Application No: BE/59/21/HH
Site Address: 339 Chichester Road Bersted PO21 5AN
Description of works: Replacement of blockwork boundary wall with fence and new vehicular access (resubmission of BE/149/21/PL)..

Thank you for your internet representation made on 6th May 2021 which has been recorded as an objection with the comments as follows:

SITE PLAN - SHOWING VISIBILITY SPLAYS
1:500 SCALE (at A3)

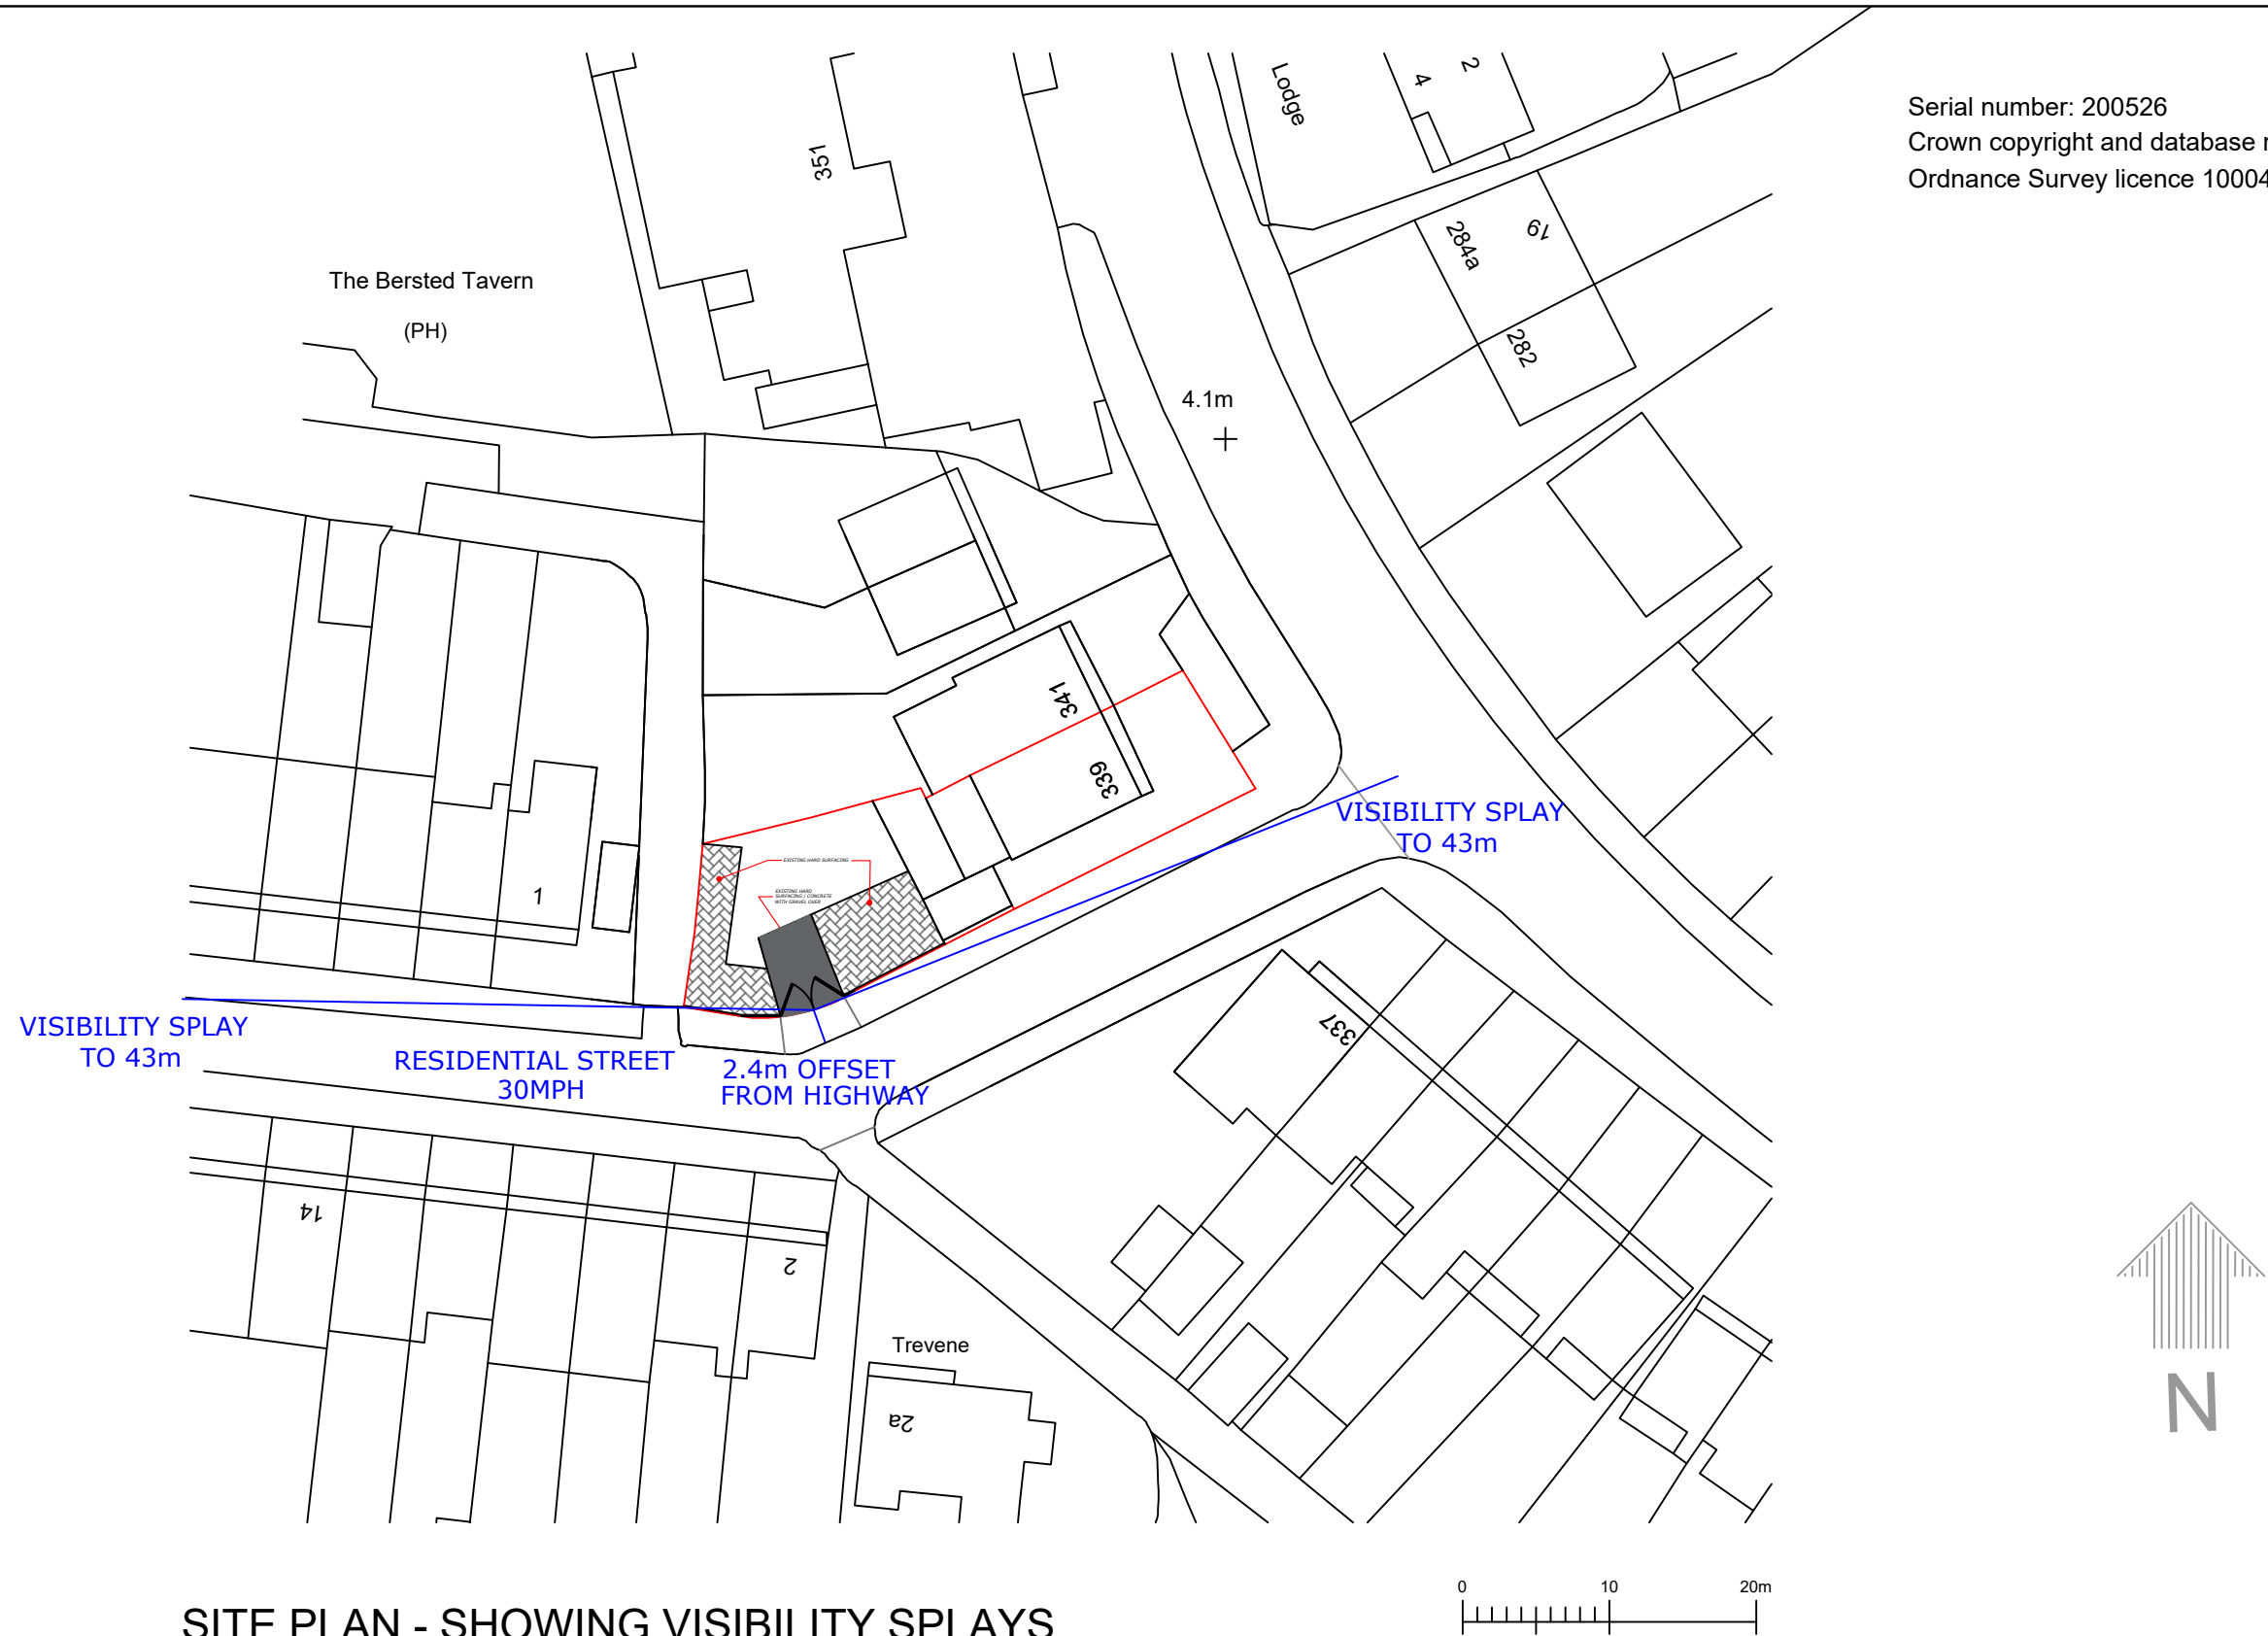
As previously commented on the application preceding this one, the property already has parking for approximately four vehicles at the front of the property. The area designated for extra vehicular access is sited on a blind bend, on a residential road (which is used as a cut through), and opposite an access road to the rear of properties on Chichester Road. Many school children use the access road to and from school and there have already been several near misses with vehicles and pedestrians on this corner. There are already many vehicles parked on the pavement as vehicles outweigh housing and access for emergency vehicles can be difficult or non-existent depending on the time of day and at weekends. This is already of major concern to the householders. As the access is to be sited on a blind bend it would make an existing dangerous situation already even more dangerous and is not needed in an already overcrowded road. The front of the property is already used as a 'hotel' or half-way residence and the road does not need a commercial business or access in addition. The extra cars from this property (from employees of Mr Delaney's business) already park over residents' driveways, turn in them and generally are a nuisance. Often being abusive to residents when asked to move. Viewing by planning officers needs to be carried out at evenings or weekends to give an insight into how bad access and sight from this application and proposed access would be and the problems that it would bring, could be easily understood. This application is not needed and certainly not wanted by any of the residents of the road.
